DECISION DELEGATED TO HEAD OF PLANNING

Application No: H07-0089-22 **Applicant:** Mr M Rowell

Proposal: Details of existing & proposed site levels & proposed floor levels and soakaway system for the disposal of surface water (Conditions 5 & 6 of H07-1252-21)

Location: Adj. 22 Station Road Gedney Hill Spalding

GROUND INVESTIGATION	Project: ADJ. 22 STATION ROAD, GEDNEY HILL	Date: JAN. '22	Designer: JL
Project No: SW 22-123	Subject:	Sheet No: SK02	Rev: -

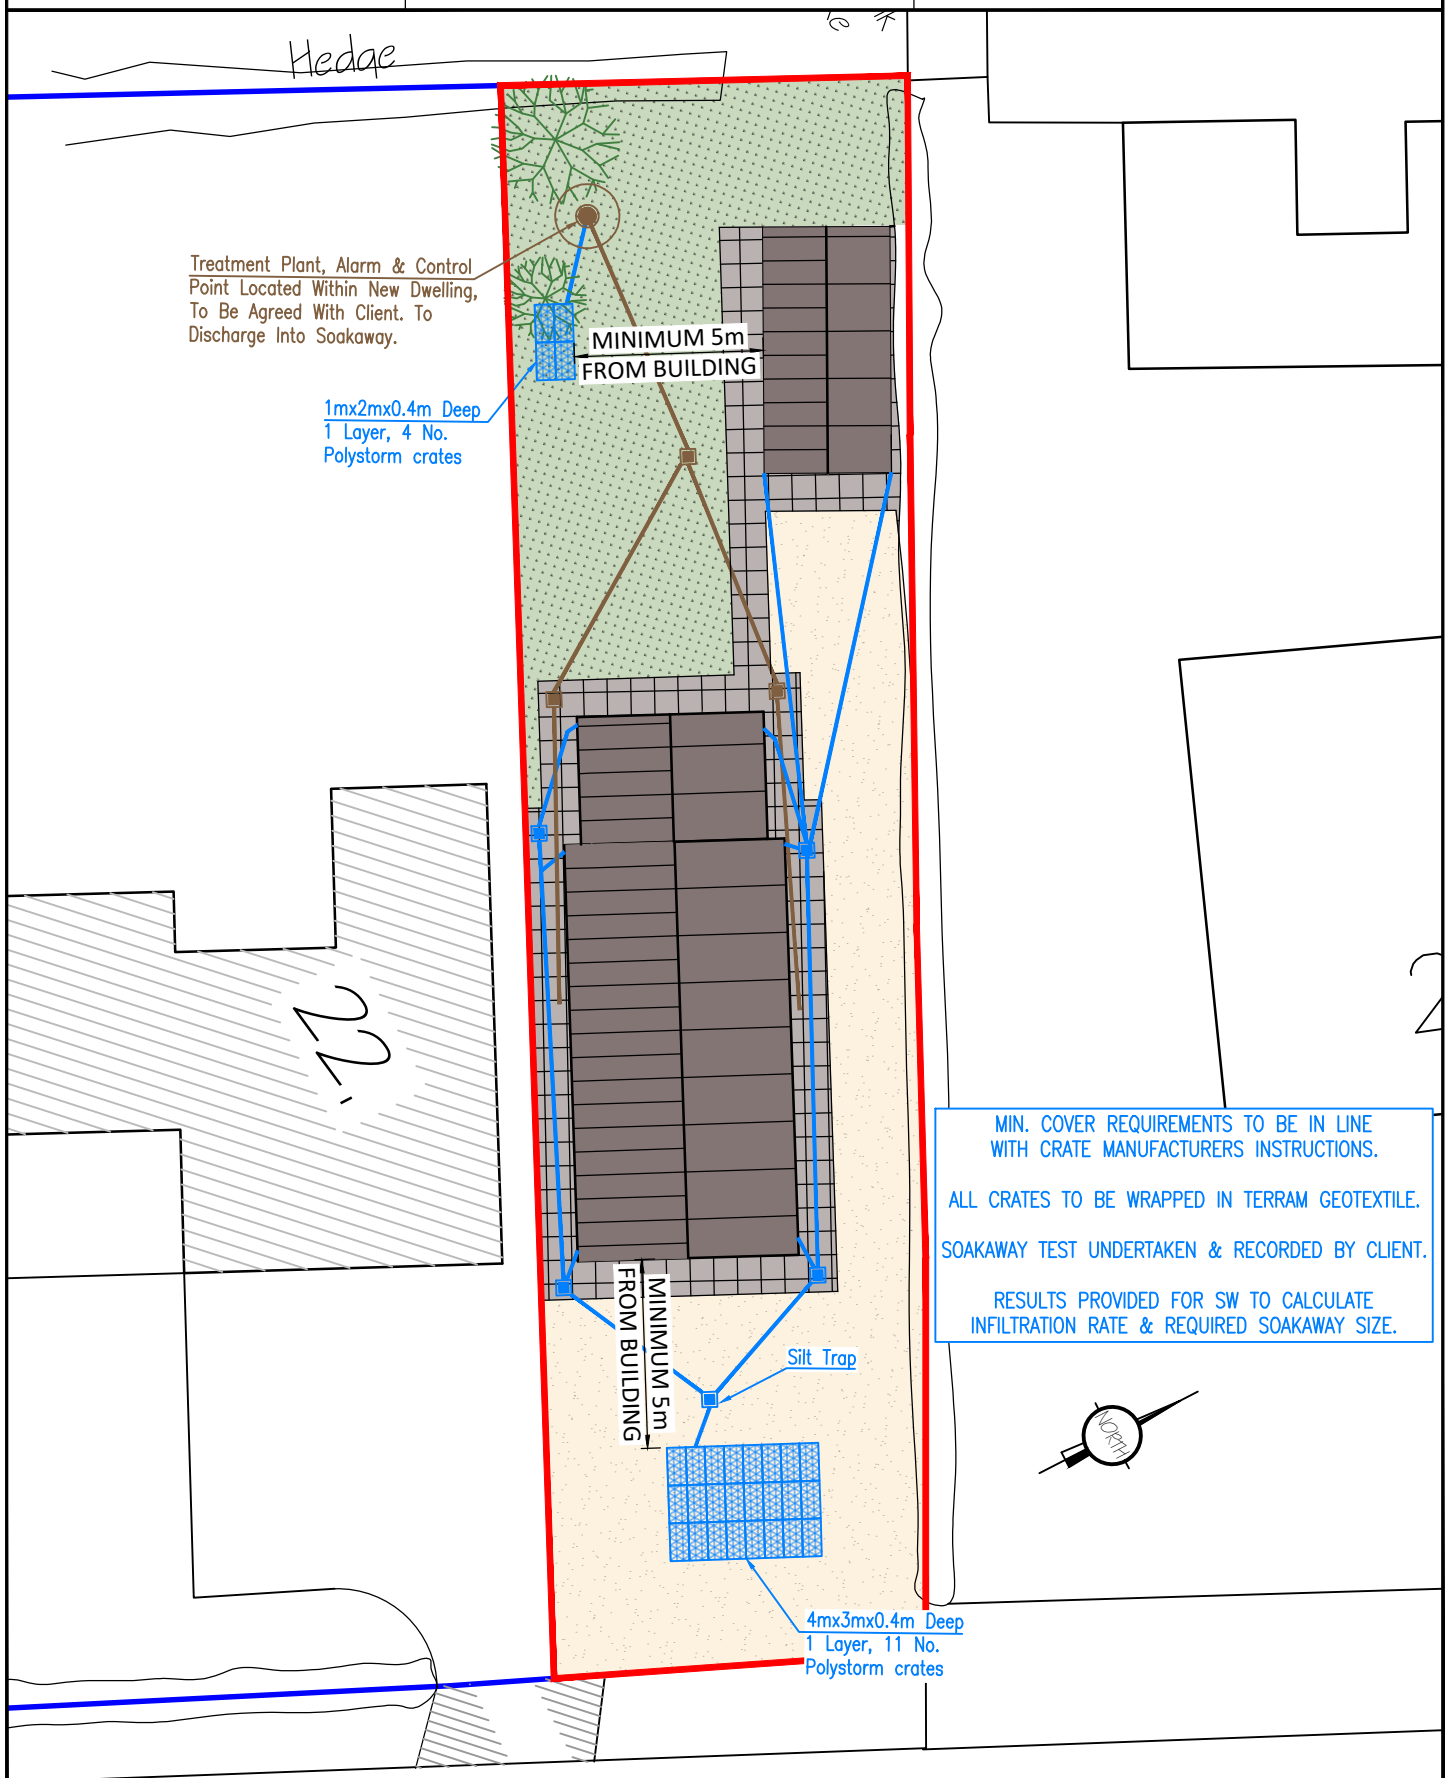
The South Holland Internal Drainage Board has objected and has advised that testing has not been carried out to BRE365 standards and recommends further testing. It has further advised that LPA assess the proposals against their own policy and national planning policy to decide whether to approve on the basis of the submitted details.

The engineer who has carried out the initial infiltration testing has advised that further testing is not required as the 2 tests carried out already, whilst not fully in compliance with the guidelines set out within BRE 365, the testing undertaken was more than adequate for the proposed soakaway designs and generally in line with the guidance. It has further been advised that undertaking a third test on a consecutive day nearly always leads to a better result than the second test on the previous day thus rendering the second test the worst case infiltration rate for design purposes. As such the testing undertaken and designs proposed are considered satisfactory.

The proposed soakaway system is considered acceptable therefore condition 6 can be discharged.
